KCH Engineering Solutions, LLC

Re: McGehee tract PCD No. SF 2011

The following is a summary of the items that were addressed based on the "redline" comments that were received from El Paso County in April, 2021.

## Exhibit 9: Existing Swale Photographs

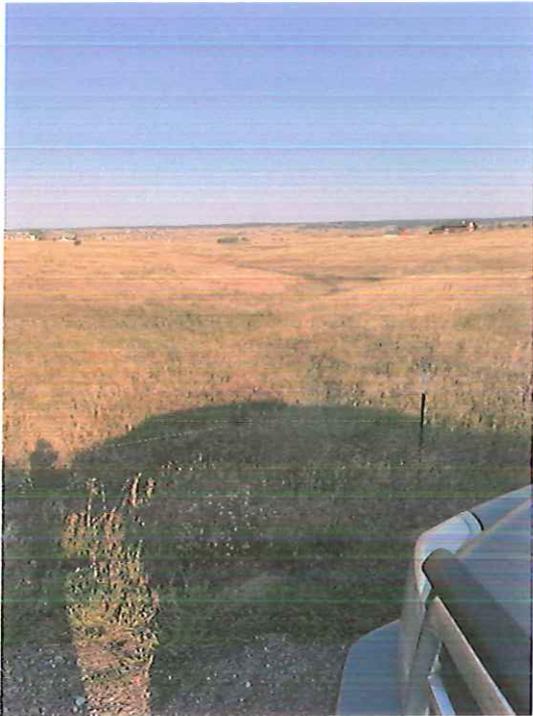
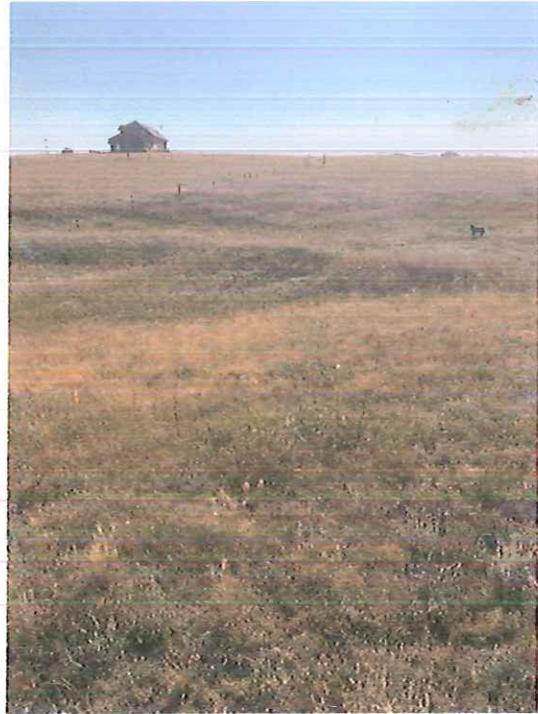
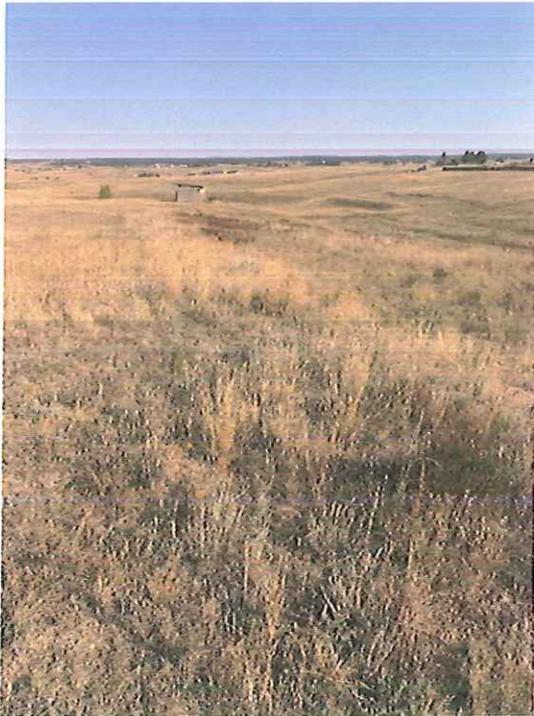
Sheet 4

- Correspondence with the State Engineers Office regarding the jurisdiction of the large stock pond is included in Exhibit 9 of the Appendix.
